Notes of todays meeitng

Key points from todays Site Plan Review meeting with MMC:

East Tower CMP - meeting was seeking to find consensus

Congress Street Closure and associated detours/emergency access (this discussion to continue longer; includes third party review of construction plan)

- a. Week one – build crane.
- b. Week 2-7 – erect precast garage.
- c. Week 8 – dismantle crane.

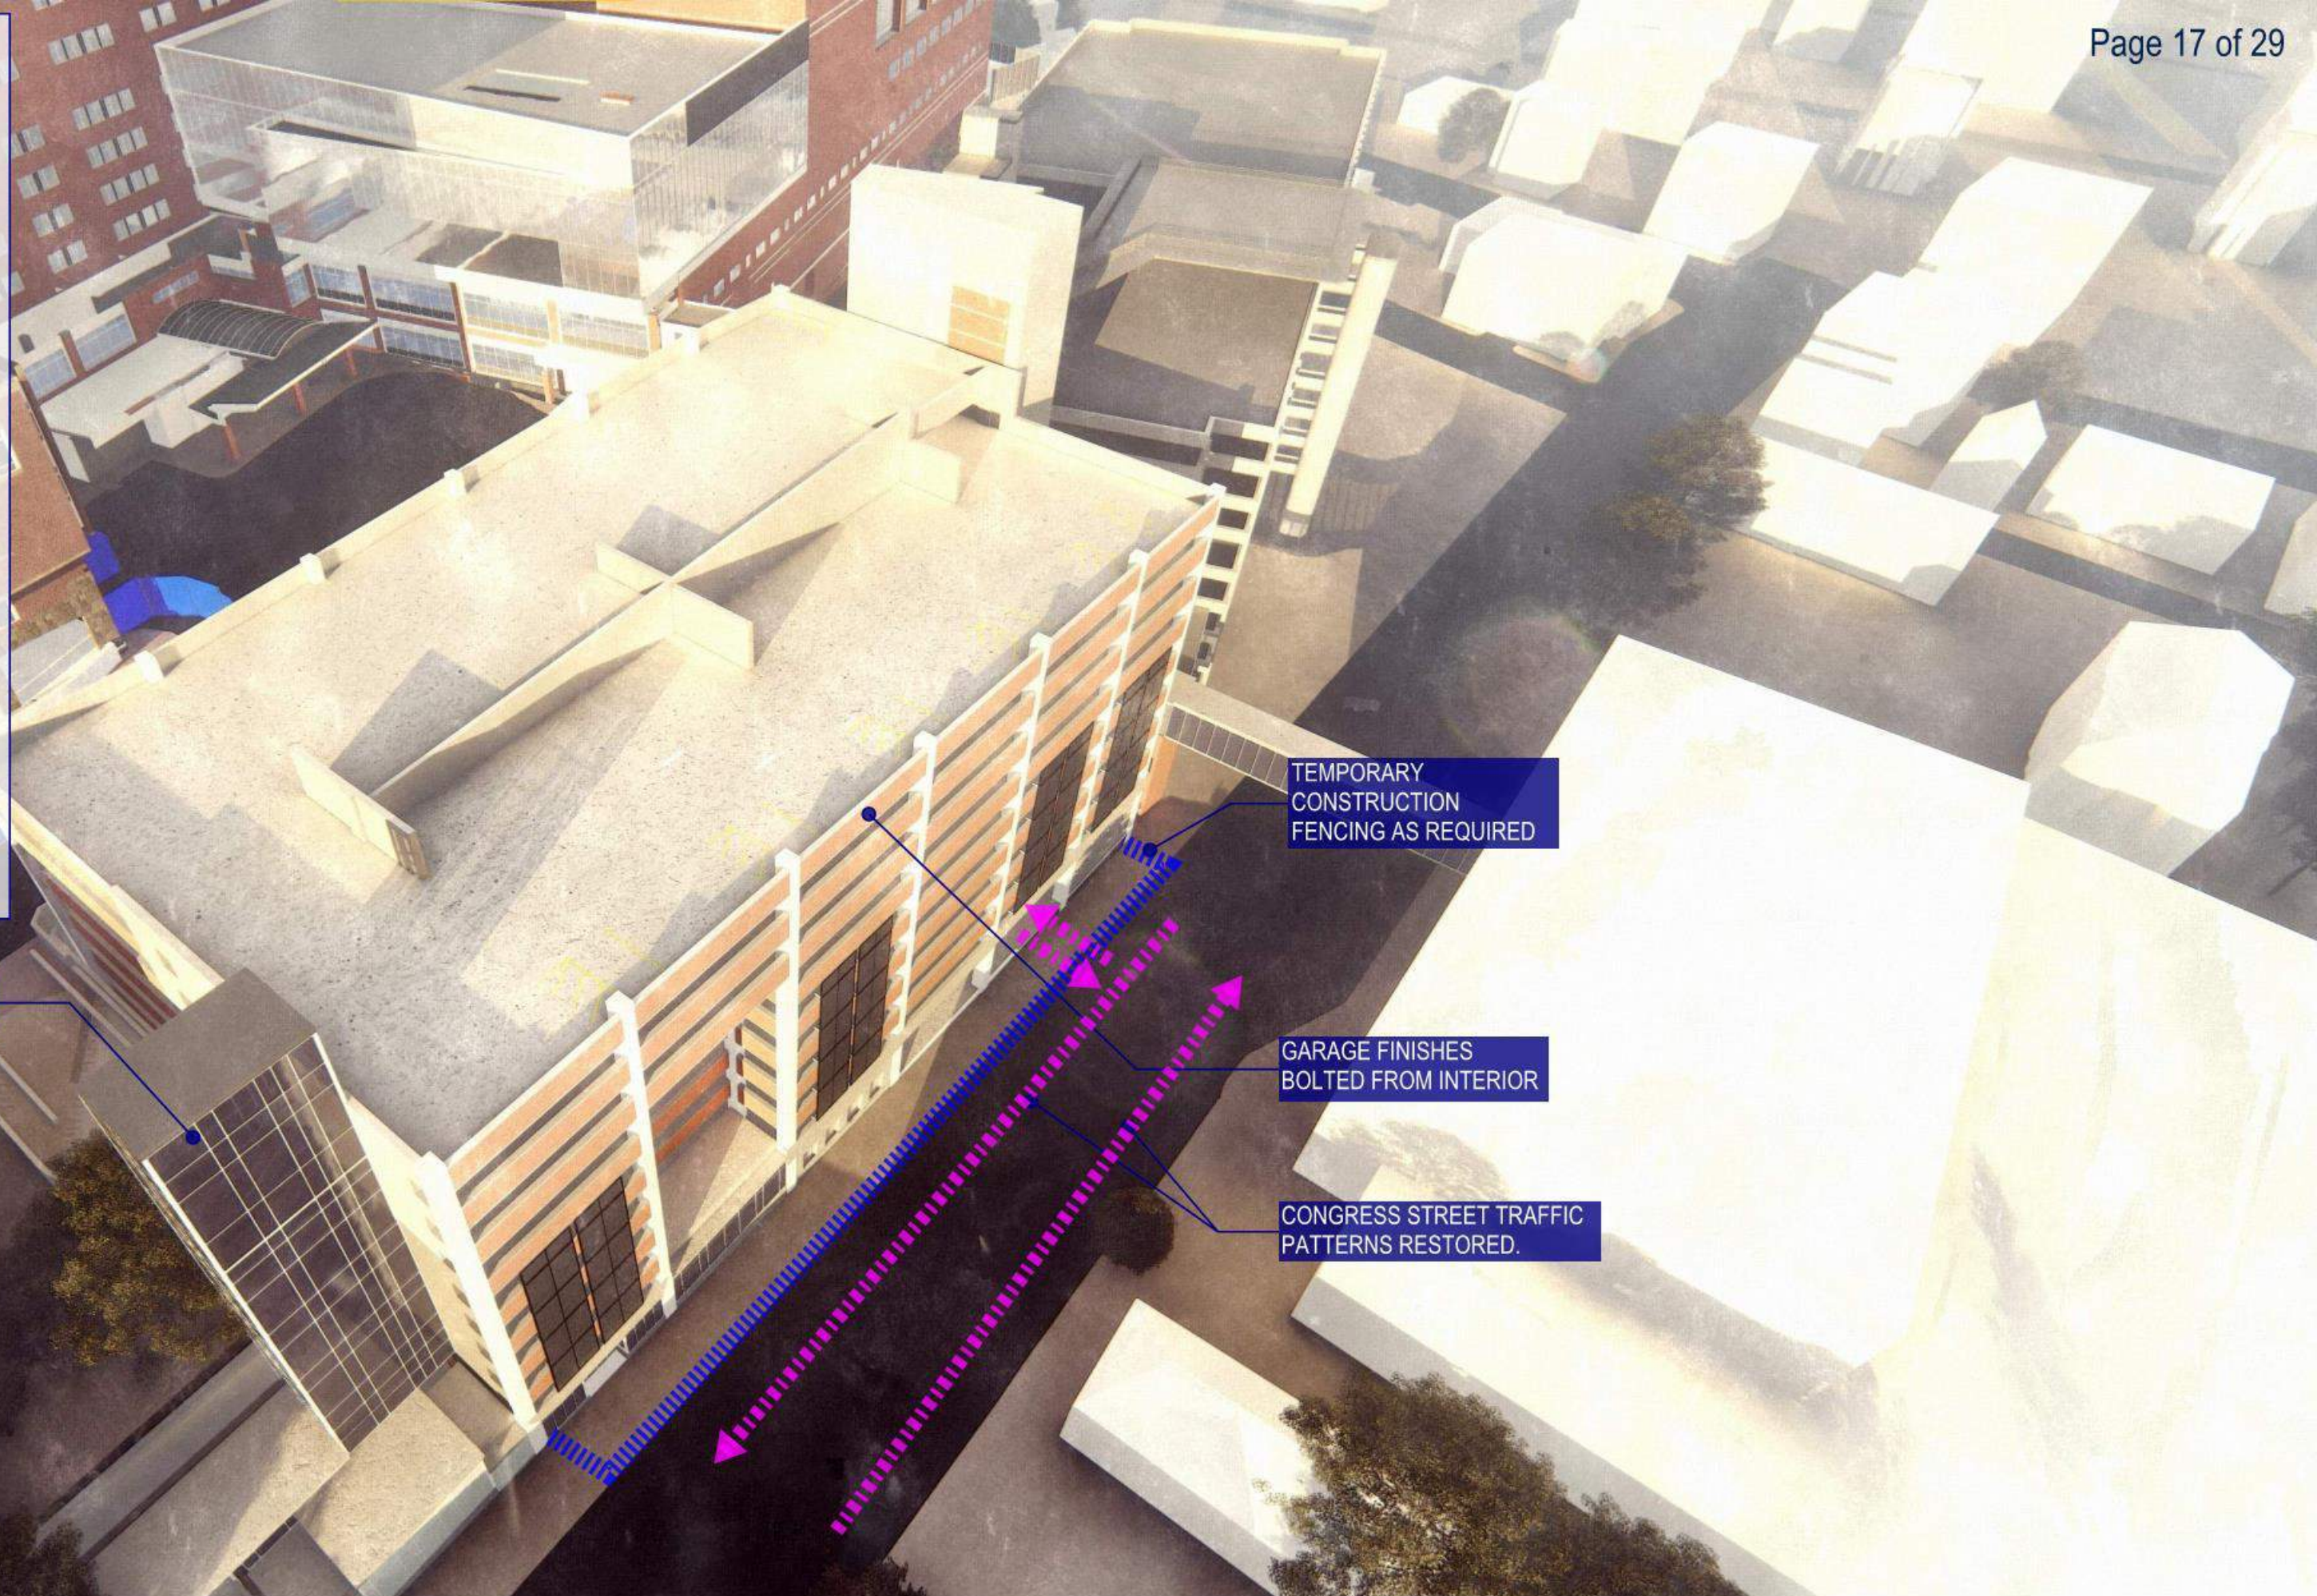
- A number of alternatives were discussed, looking at pros and cons (eg access from Gilman) as Turner proposals problematic Ellsworth to Congress and reservations over 2-way in Crescent
- MMC noted secondary access via employee garage for cars going to Visitors Garage
- Concluded:
 - Take out bumpout in Crescent to help larger emergency vehicles
 - Best option for exiting trucks is Bramhall via Charles to 295
 - Keep Crescent 2-way (MMC contacting residents long here re need to remove parking)
 - Gilman could be back up access option and arranged if necessary

- Current plan is for 8 week closure based on normal working practices, so May 7 to June 28 envisaged
- Compression of time means more trucks in area per day

- Need to get people out of system further out - need signage
- Police suggest closures on Congress at St John, and Park
- Many felt should avoid pushing traffic to Weymouth
- Deering another option - G-P to include in analysis
- Park 2-way offers benefits but big questions re intersection modifications and signals
